From: [Michael Flory](#)
To: [Dusty Pilkington](#)
Subject: RE: VA-16-00001 Mostofi
Date: Tuesday, September 06, 2016 11:17:27 AM

RE: VA-16-00001 Mostofi

VA-16-00001

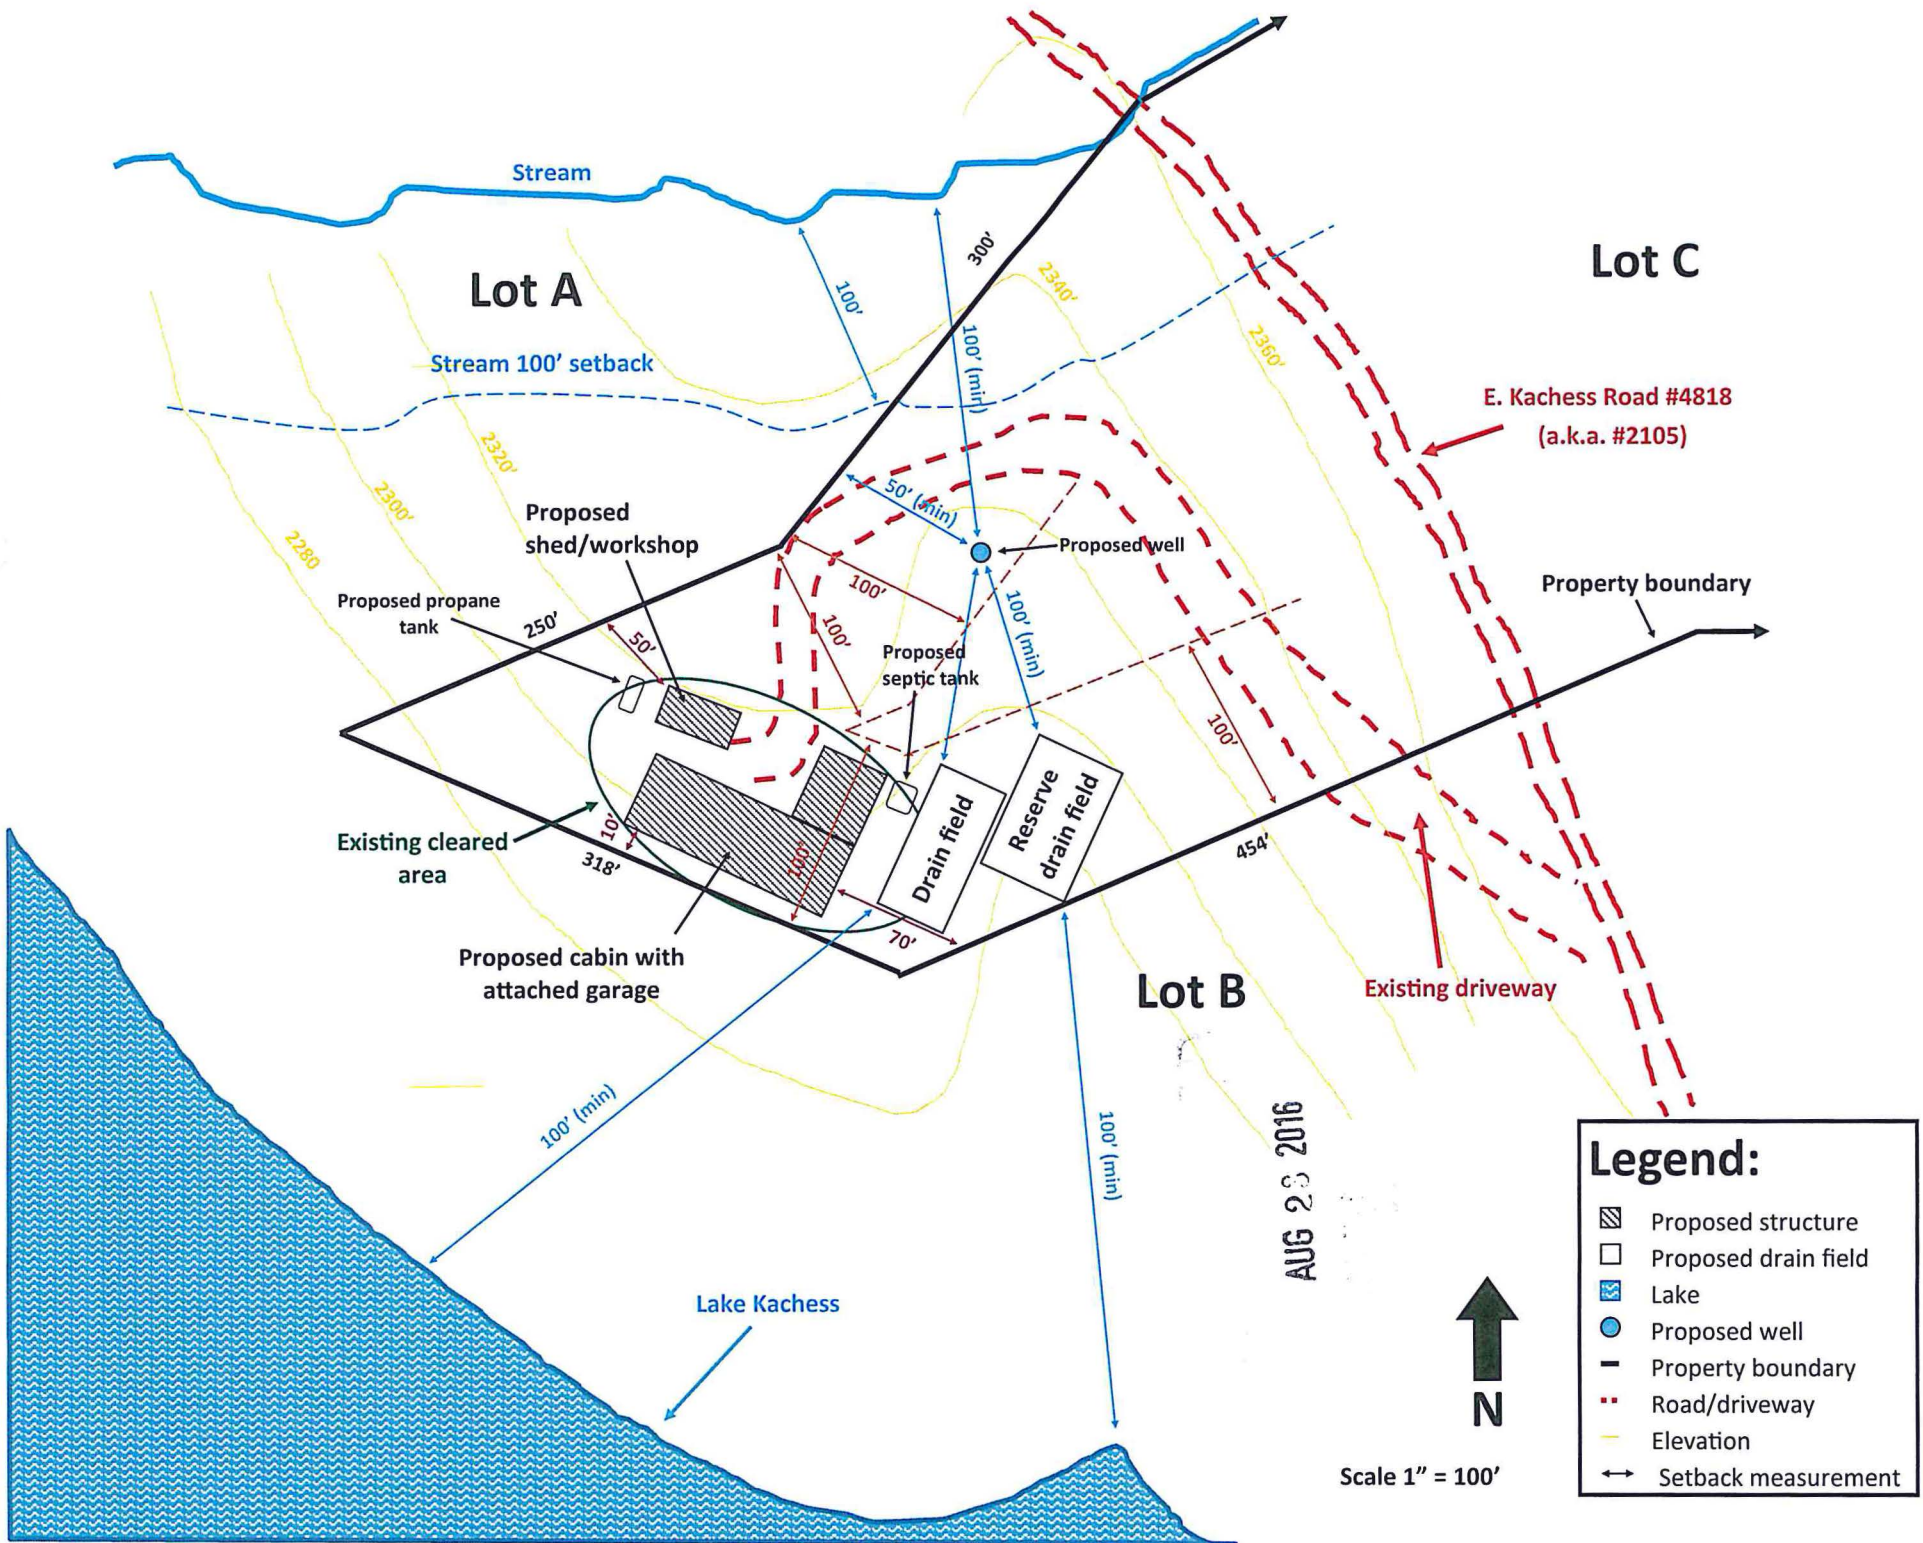
1. The CDS Building Division has no objection for the applicant to encroach into the setback. Distance to be determined by Planning Division.
2. Due to steep slopes on the property, full geo-tech and soils report is required as well as engineered building plans.
